Engineers Comments Regarding Surface Water Drainage

Application Reference:	P/110/25/DOC	Reviewer Reference:	ADC/Ext4
Planning Officer:	Simon Davis	Date of Review:	13/11/2025
Site Name:	Land West of Pagham Road Pagham Road Pagham PO21 3PY		
Application Description:	Approval of details reserved by condition imposed under reference P/178/21/OUT (APP/C3810/W/22/3302023) relating to condition number 11 - foul drainage system, condition number 12 - surface water drainage, condition number 13 - discharge rates of watercourses and condition number 14 - management and maintenance of surface water drainage system. (See P/109/25/DOC for condition number 17 - contamination, condition number 22 - internal noise level, condition number 24 - broadband provision, condition number 26 - bus stop information screens and condition number 28 - acoustic.).		
Assessment Number:	1 of 2

Application Reference: P/110/25/DOC Site Name: Land West of Pagham Road Pagham Road Pagham PO21 3PY	Initial Issue Date: 13/11/2025 Issue Date: 13/11/2025 Reviewer Reference: ADC/EXT4
--	---

scale 1:500	drawn by FA	checked by SL
date APRIL 2025	cad file CONTRIBUTING AREAS PLAN	
title CONTRIBUTING HARDSTANDING AREAS PLAN

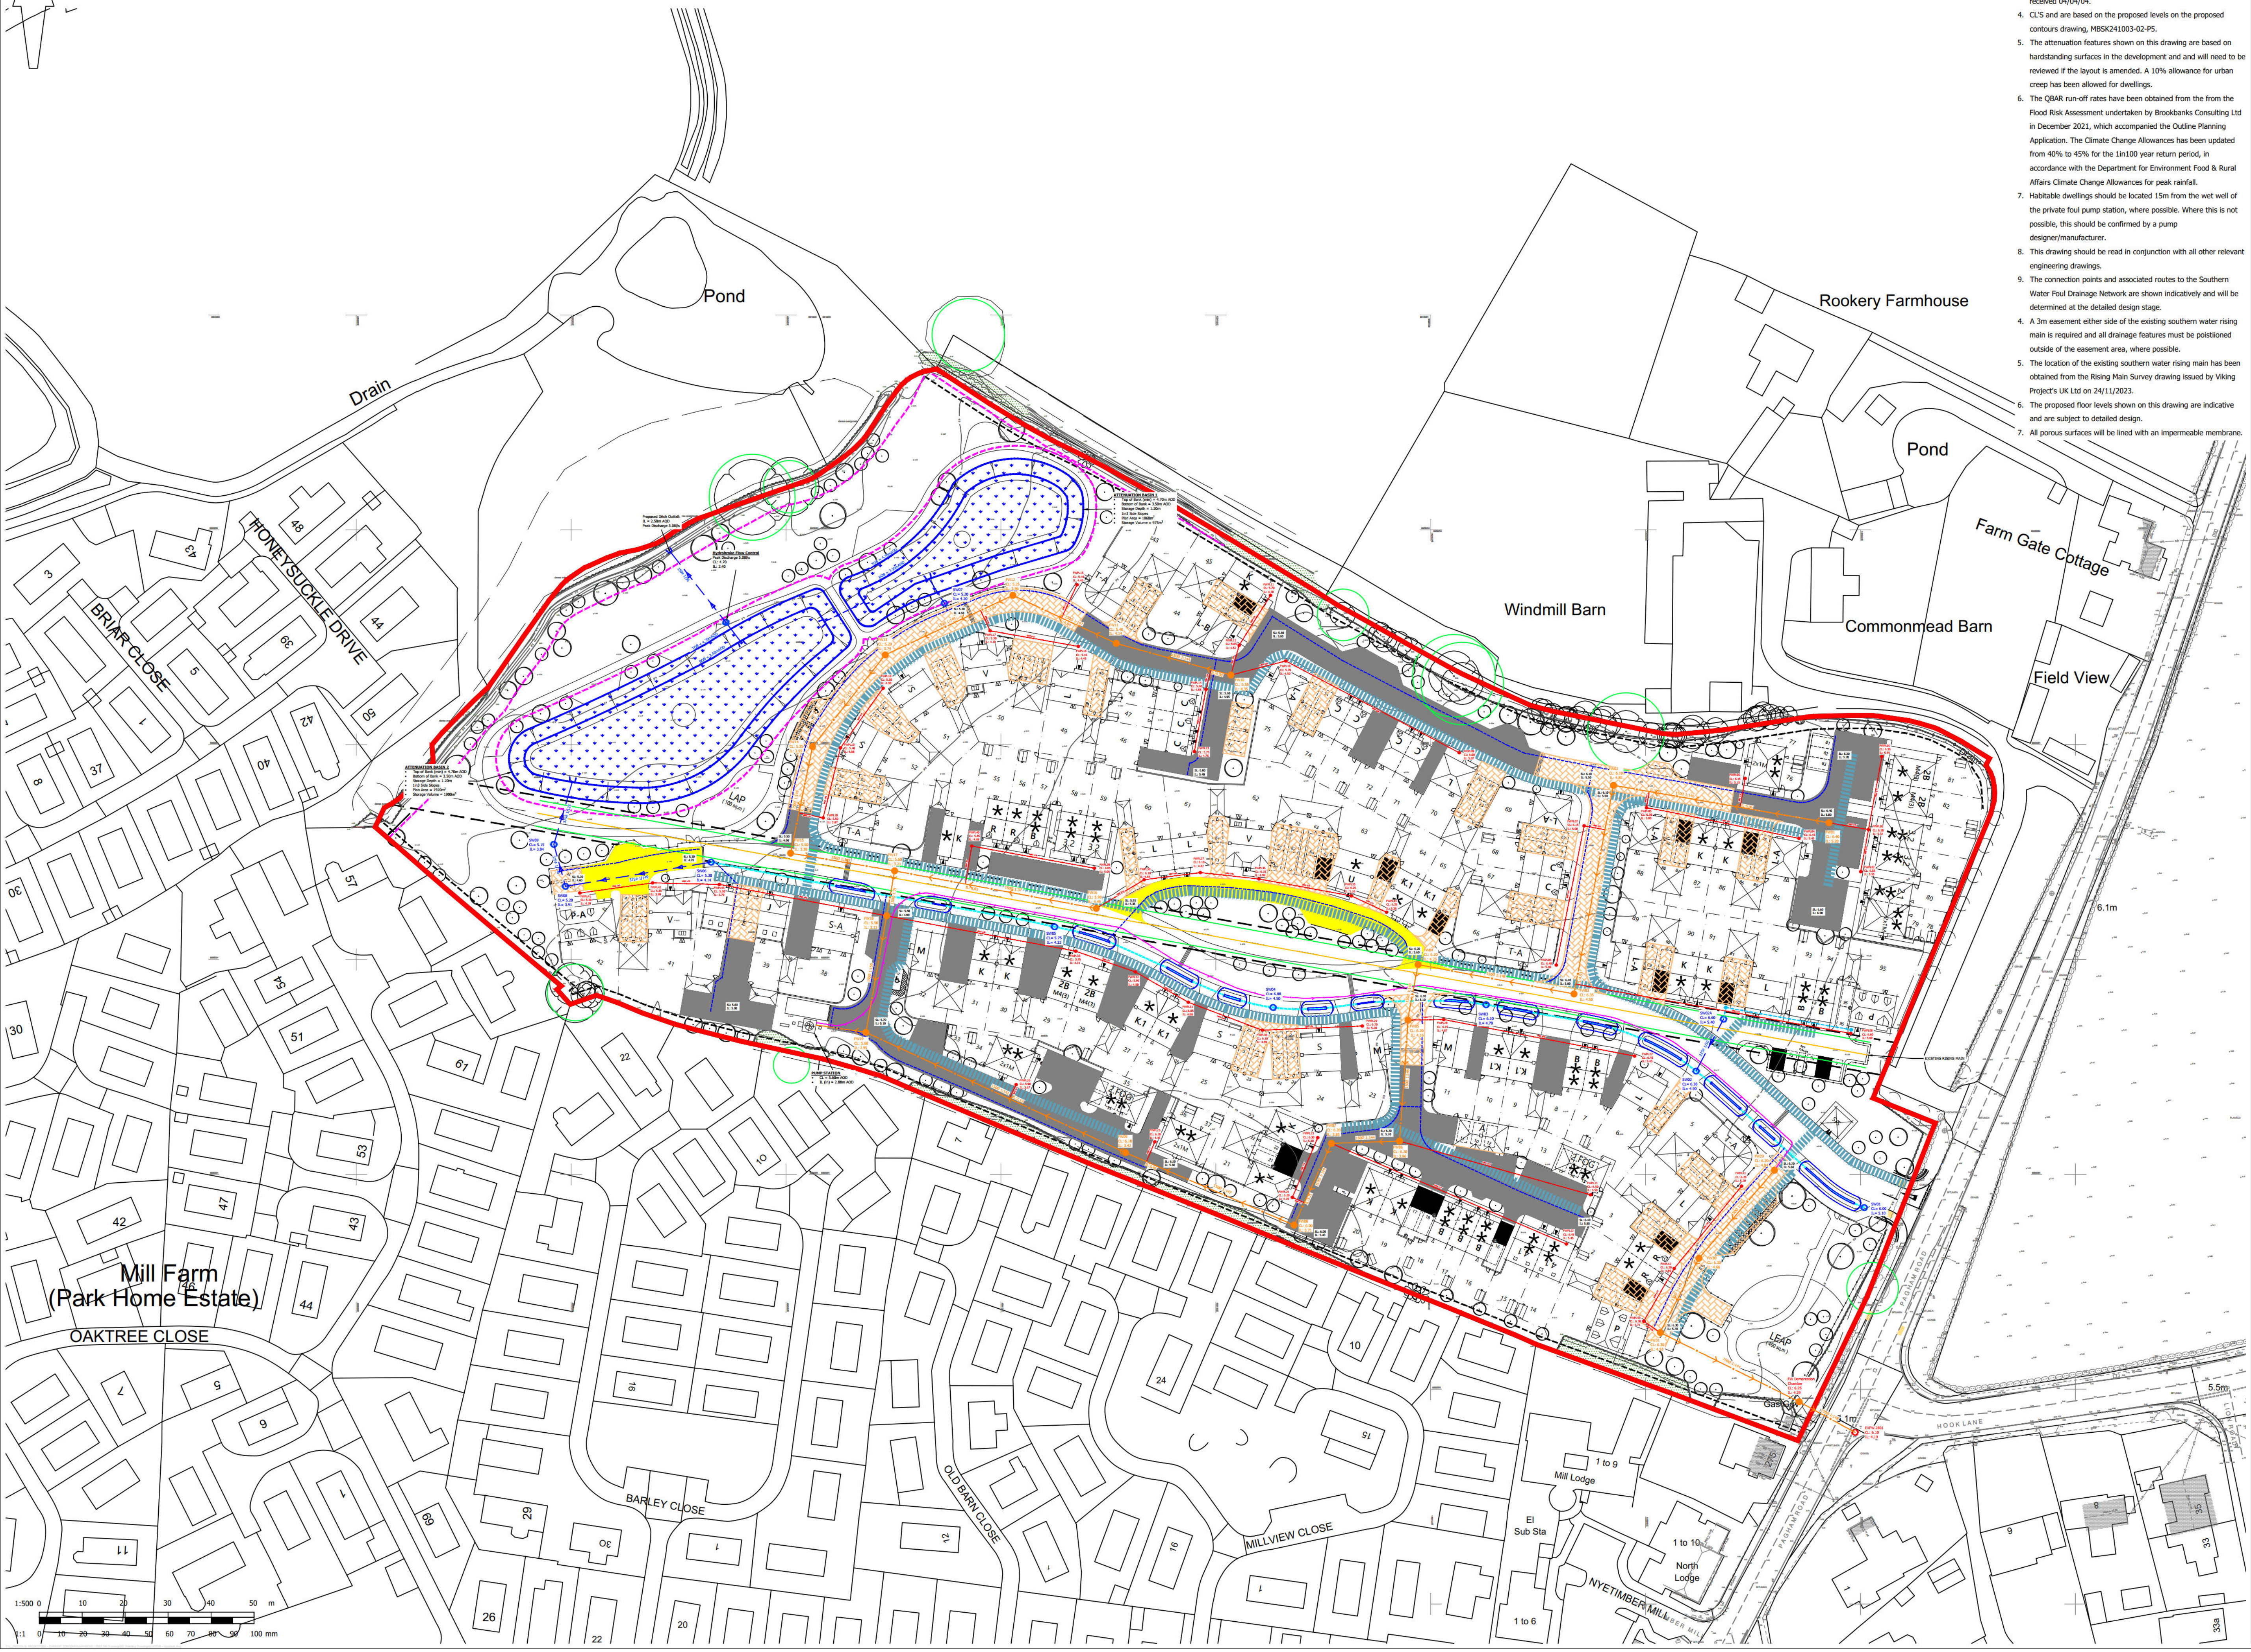
3.	Please provide further details on the contributing area catchment plan. Specifically provide a breakdown on which areas enter in specific pipes/manholes and making clear references to the pipe numbers/manholes on the plans and supporting calculations.	This is now included in Appendix G within the updated Technical Note.
